2210361

**RESPONSE TO SUBMISSIONS – BUILDING R4B
SSD 6965 MOD 3**

This response to submissions letter has been prepared following the public exhibition of a section 4.55(1A) modification application for Residential Building R4B, Barangaroo (SSD 6965 MOD 3). The modification application seeks approval for internal and external design changes and administrative amendments. The modification is supported by concurrent modification applications to the adjacent Residential Building R4A (SSD 6964), and also to an Alterations and Additions development consent to Building R4B (SSD 8892219).

Drawing: BR4B _ASD_PA2_4004
Date: 18 JUN 2021 Revision: 2
SECTION 4.55

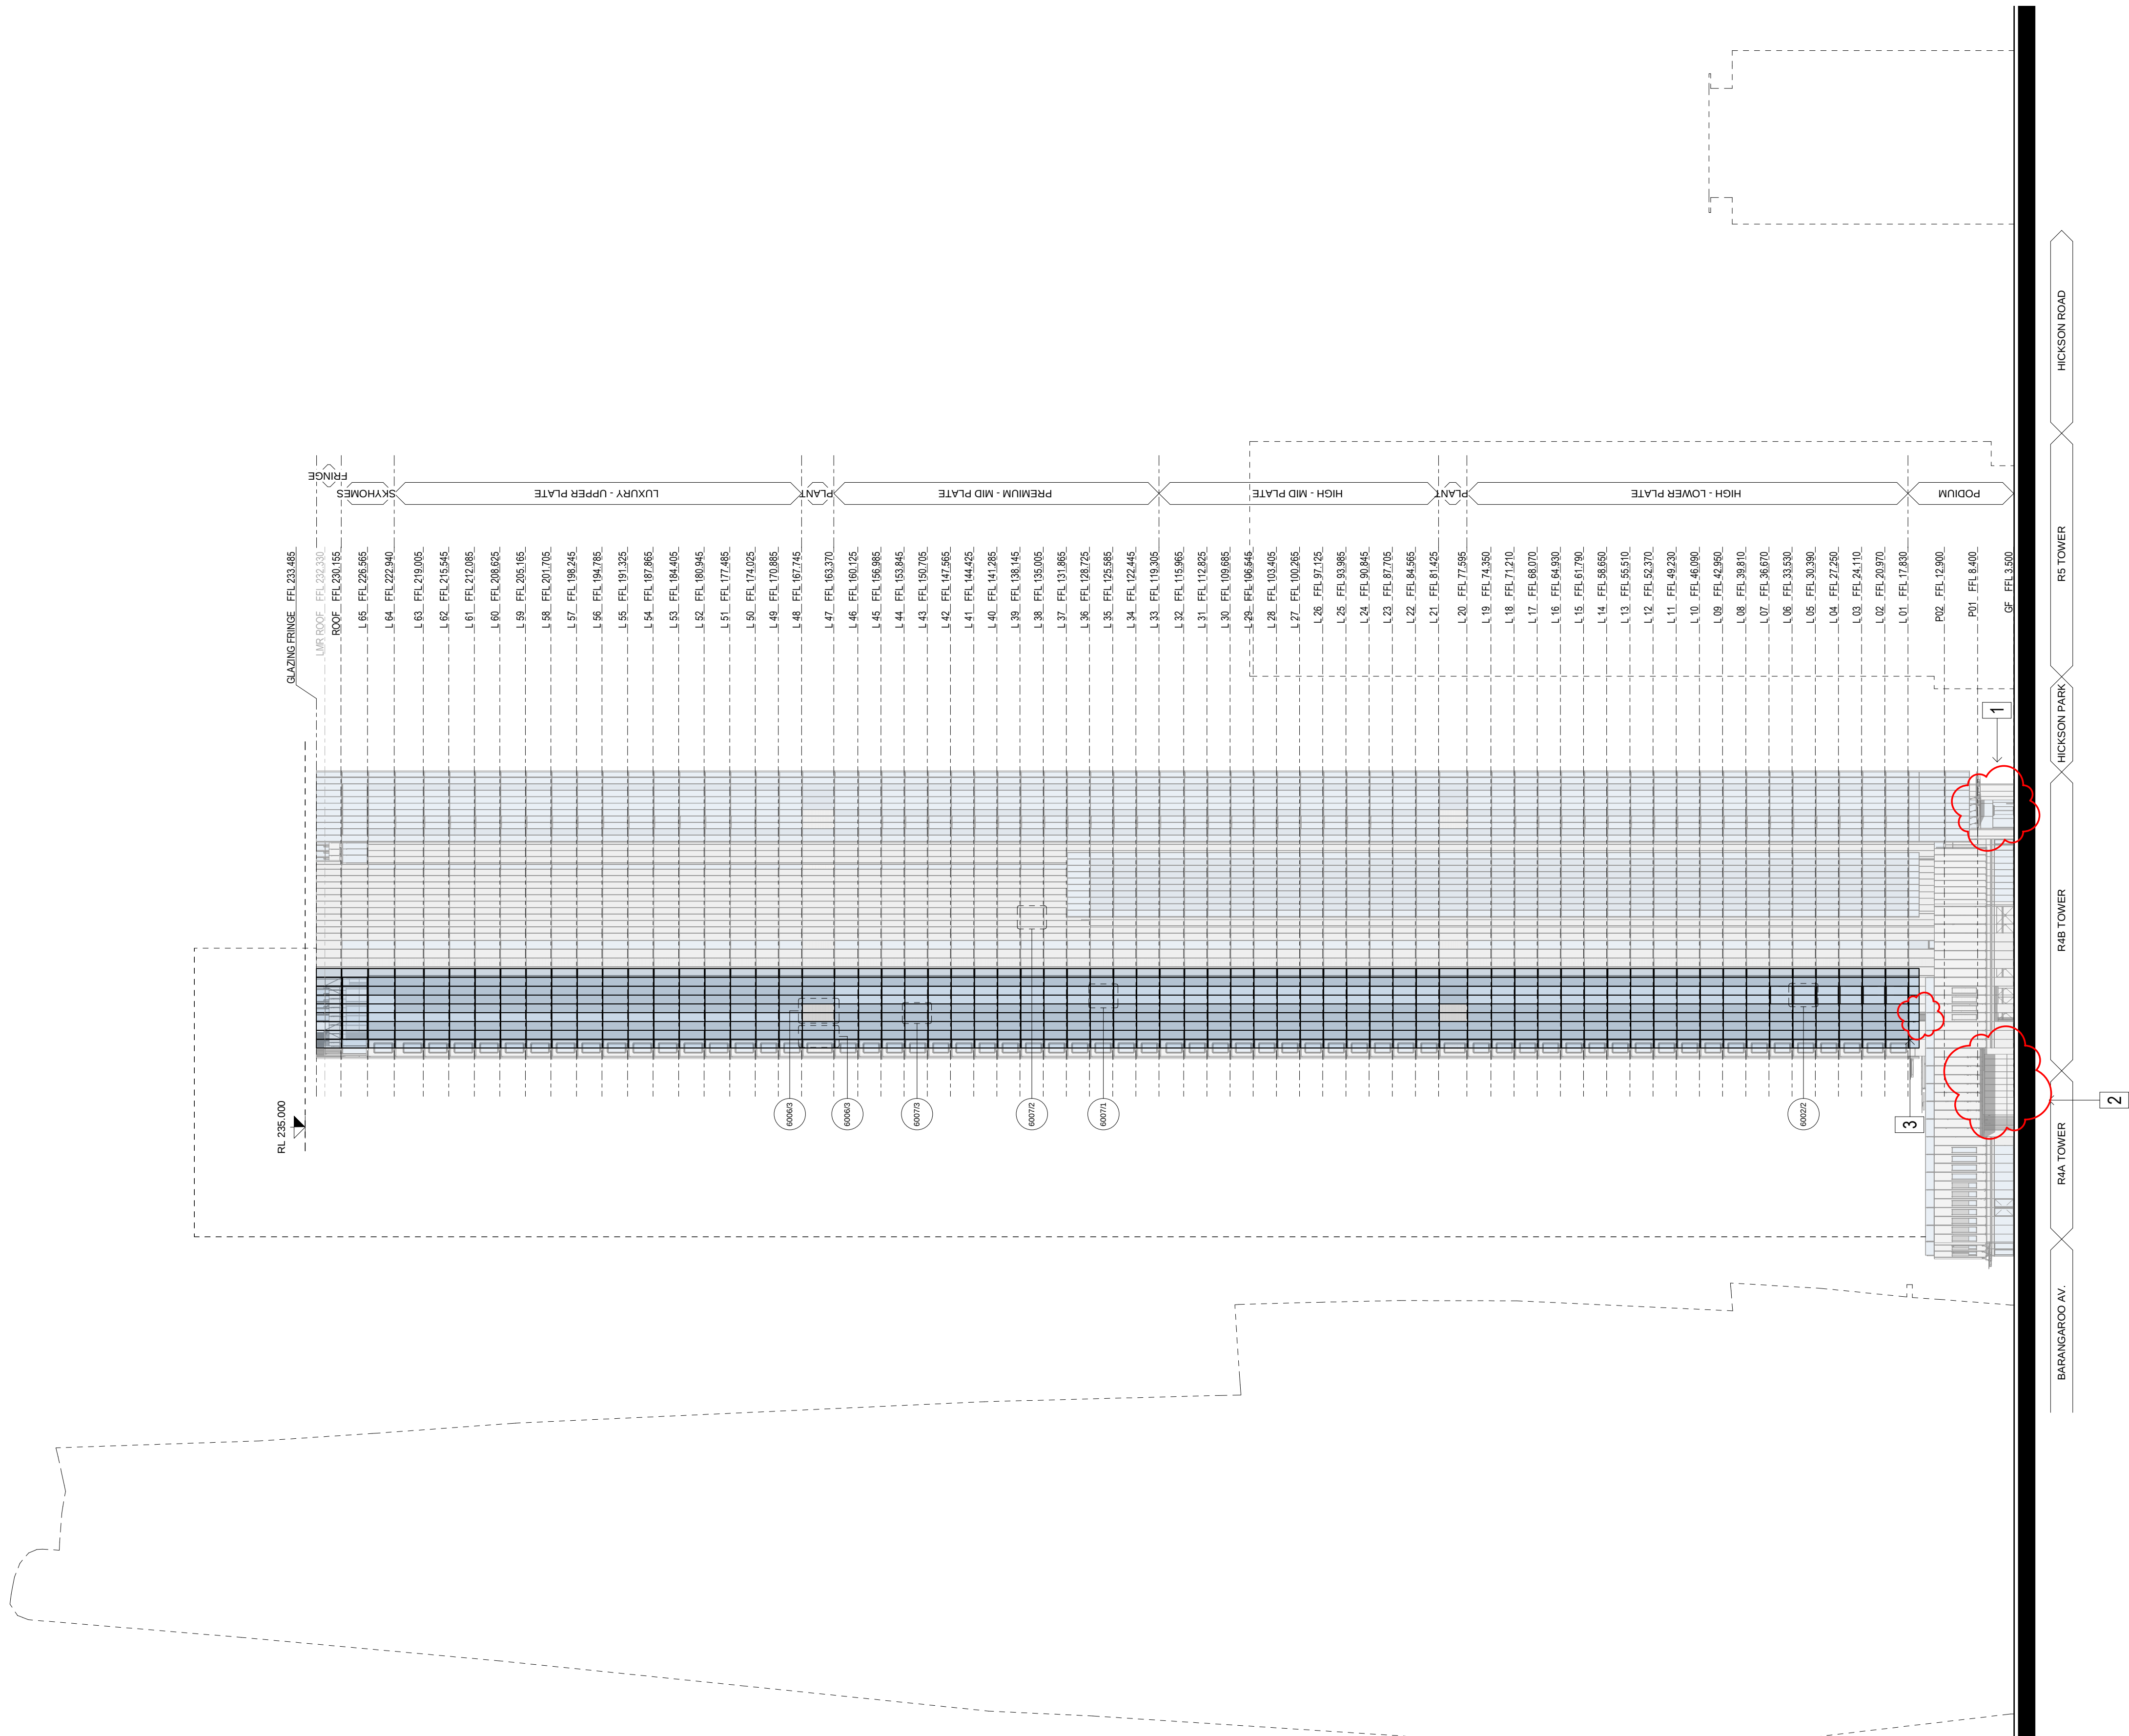
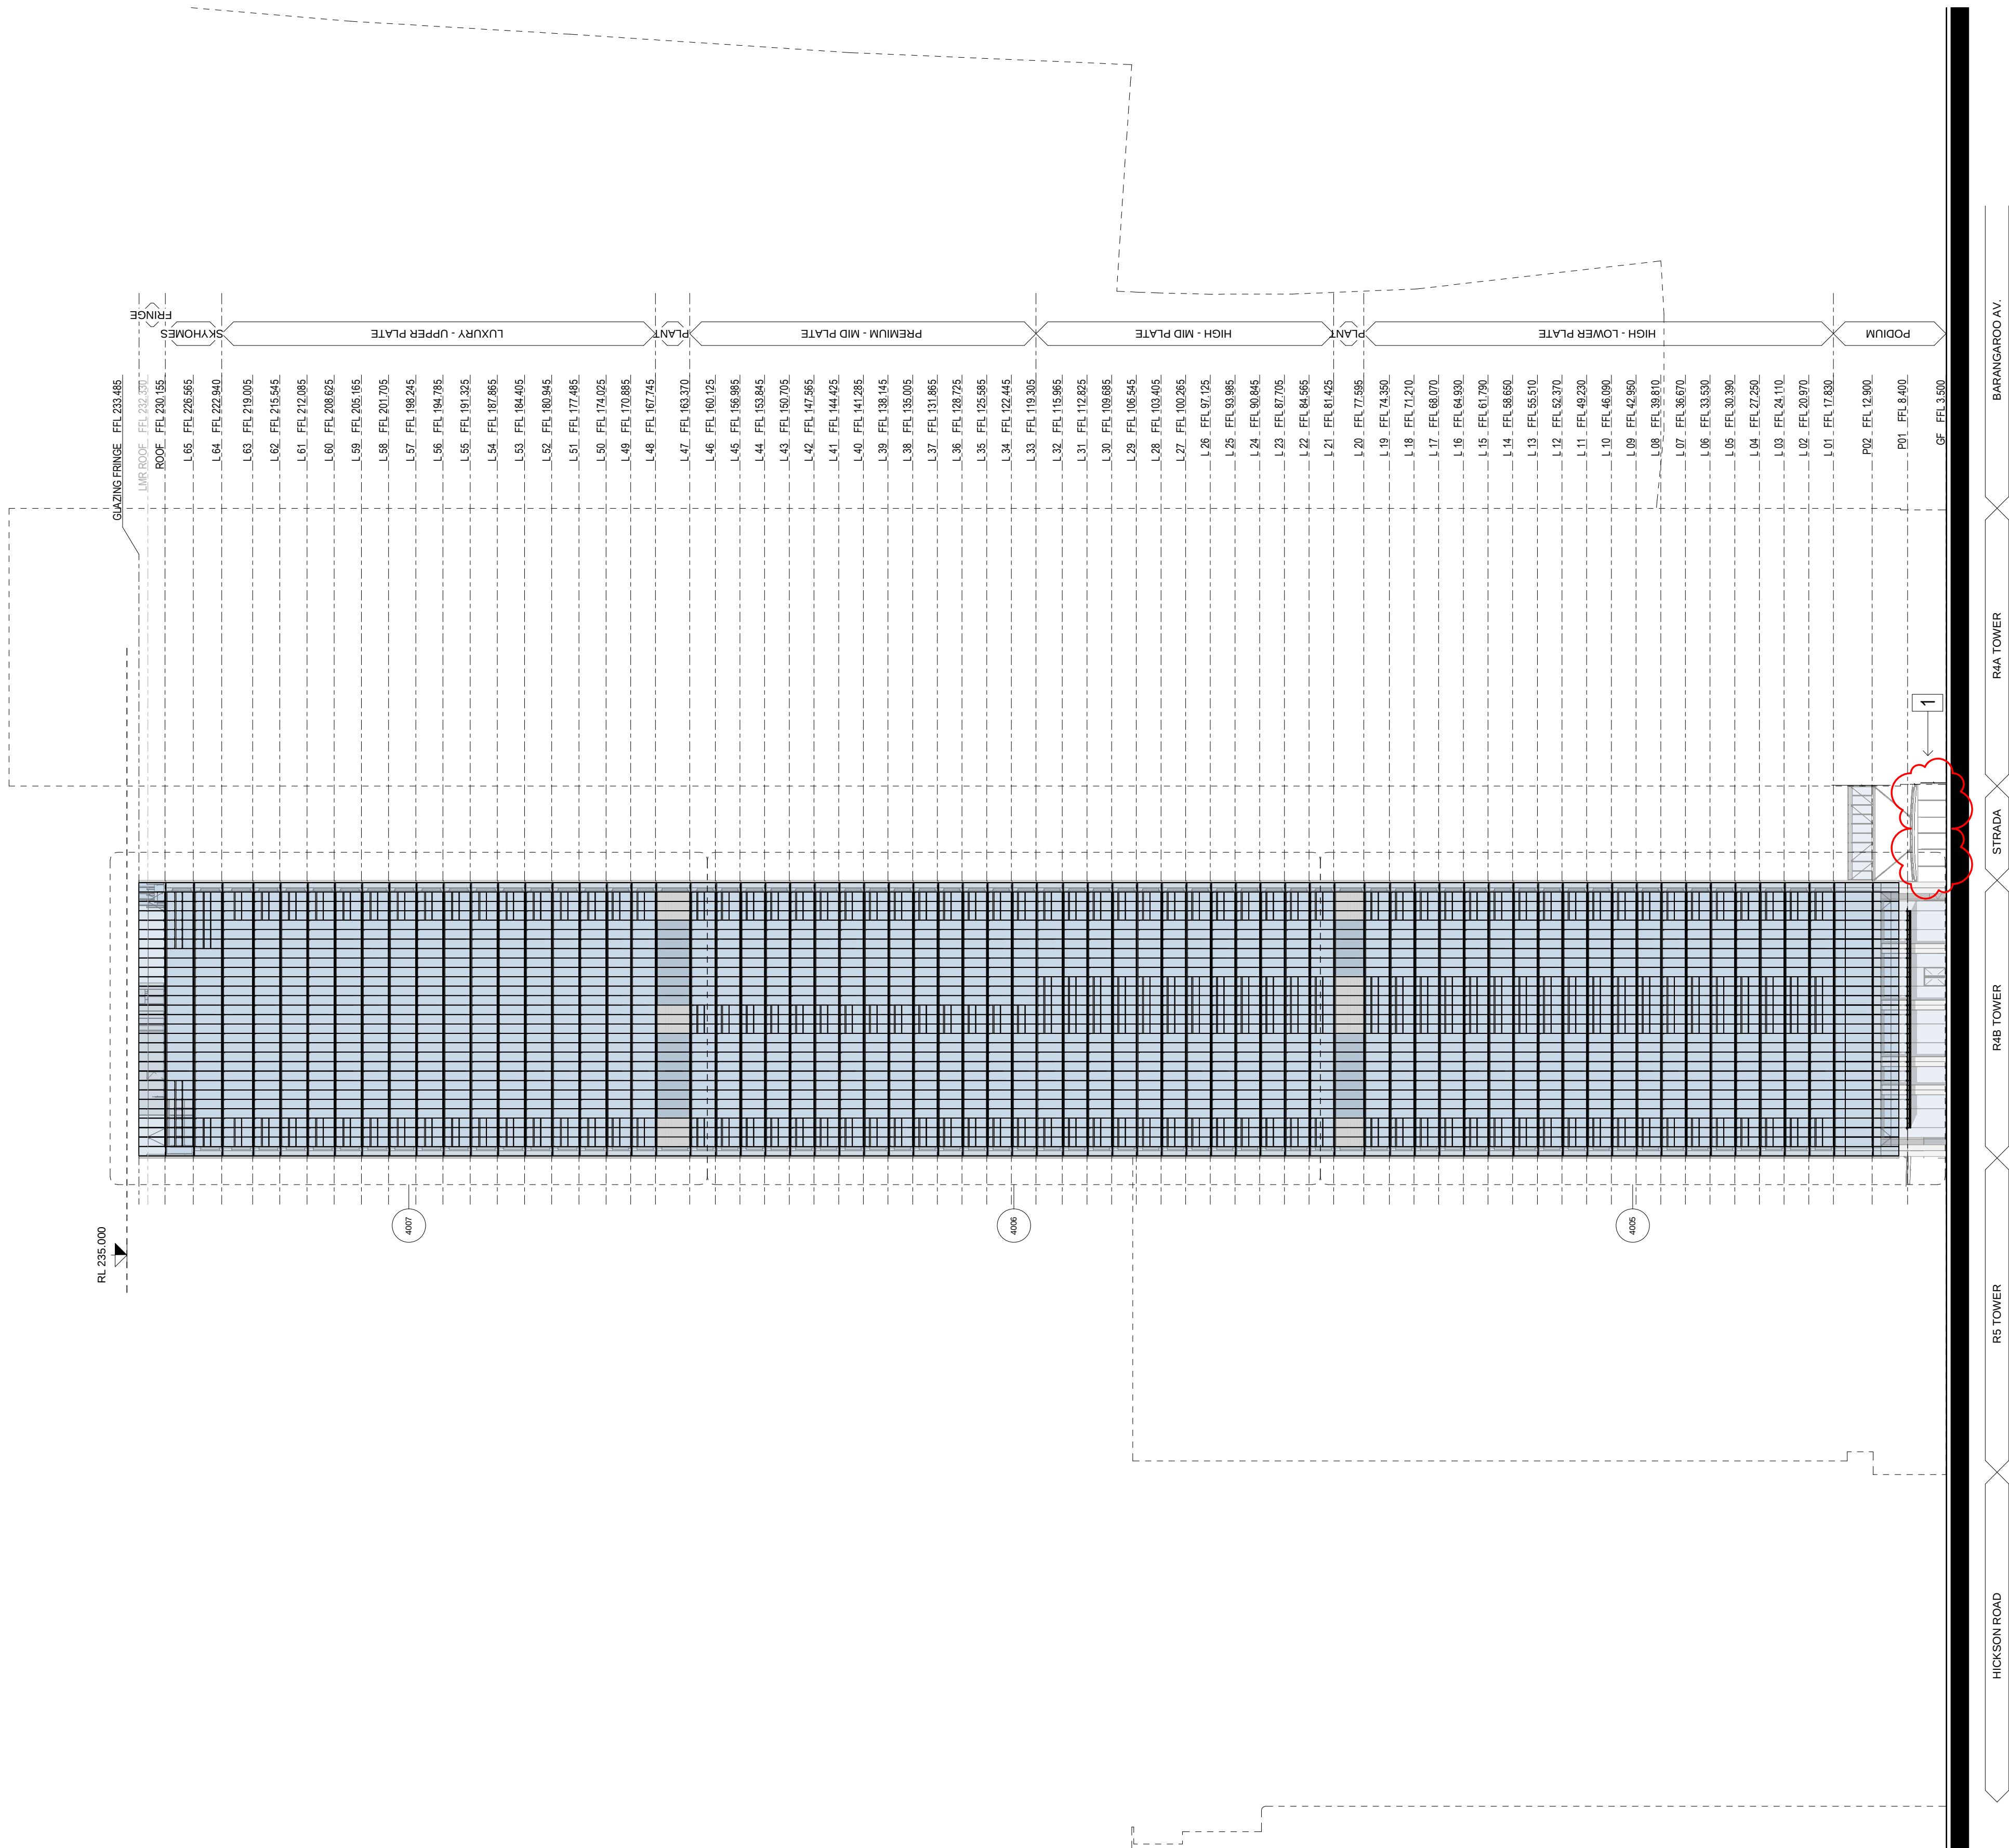
The submitted plans indicate that the ramp door is proposed to be relocated and the facade be updated, and the design report notes the carpark entry width is proposed to be increased, however, no details are provided as to the proposed new width of the opening.

The City generally recommends, as per Section 3.11.11 of the Sydney Development Control Plan 2012, that carpark openings have a maximum width of 4m to ensure pedestrian and cyclist safety and amenity is prioritised. The proposed opening of over 10m is significantly wider than this recommendation and reconsideration should be given to this aspect of the proposal.

The Building R4B basement entry driveway on Watermans Quay was originally approved to have a width of 9.6 metres. The proposed modification application seeks to widen this driveway entry by a minimal amount of 0.7 metres to a total width of 10.3 metres, within the bounds of the current building structure. This slight increase in width is proposed to reduce the risk of vehicle impacts with cladding on either side of the entrance ramp and to reduce potential conflicts with vehicles approaching in opposite directions when utilising the driveway. There is no change to the access lanes within the entry, with the amendments to enhance safety and operation.

Alongside the increase in driveway width, Council's stone paving is also proposed to be increased into the area to improve visual outcome, alongside the adjustments made to the wall cladding. The awning above the driveway is also sought to be adjusted to reflect the increased width, and ensure a holistic design outcome. The revised Design Report at **Attachment A** illustrates the widening of the awning and driveway, demonstrating that there is minimal change and the integrated design approach will ensure the driveway is not out of character with the overall design of the public realm and building interface. A diagram indicating the increased width of the driveway is shown at **Figure 1**.
